**Consultation Response from Alan Smith,
KC Waste Strategy (Refuse & Recycling)**

2024/92848 Marsh Carpets, 82-84, Westbourne Road, Marsh, Huddersfield, HD1 4LF

Alterations to convert first floor to 2 dwellings; sub-division of one ground floor retail unit to three retail units (use class Ea); installation of new shop fronts to south and east elevations and construction of external staircase to northern elevation including associated works

Date Responded: 11/09/2025

Drawing:  
**Proposed Floor Plans**

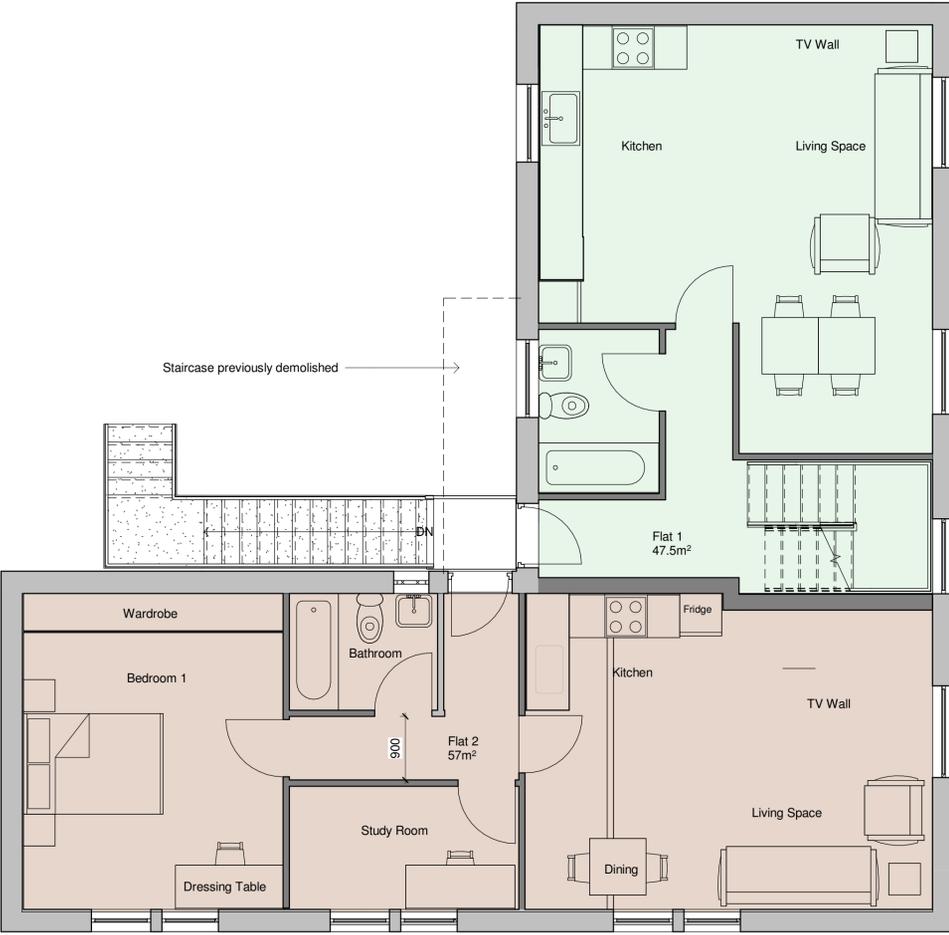
- Each dwelling will need space for 2 x 240ltr bins, 1 x 240ltr for residual waste and 1 x 240ltr for recyclable waste. Due to future changes to waste collection, due to the implementation of Simpler Recycling legislation, space will be needed for an additional 1 x 240ltr bin.

- Any waste store should be secure to prevent theft, unauthorised use / fly tipping or rough sleeping. If there are doors to the bin store and have a key / keypad to secure them these access details will be required by the collection staff. It should also be of suitable dimensions to accommodate the necessary bins and constructed in compliance with the details specified in the design guide.

- Layout drawings for this development site will need to show bin storage and bin collection points for all dwellings to demonstrate sufficient space and efficient collection arrangements – these must not cause obstruction to the highway, driveways or be blocked in by cars. Bin presentation space should be identified for each plot, on a hard surface and where a refuse collection vehicle (RCV) can be easily reached.

Additional information is required detailing waste storage, number and size of containers, capacity and design of the waste storage compound(s) including, surfacing, security and fire prevention measures.

- A. Before development commences, further details to ensure suitable storage, and access for collection of wastes from the dwellings and commercial properties shall be submitted to and approved in writing by the Local Planning Authority. The approved details shall be provided before first occupation and shall be so retained thereafter.
- B. Before development commences, details of the management and maintenance of communal refuse storage areas by a designated private management company shall be submitted to and approved by the Local Planning Authority. The approved details shall be provided before first occupation and shall be so retained thereafter.
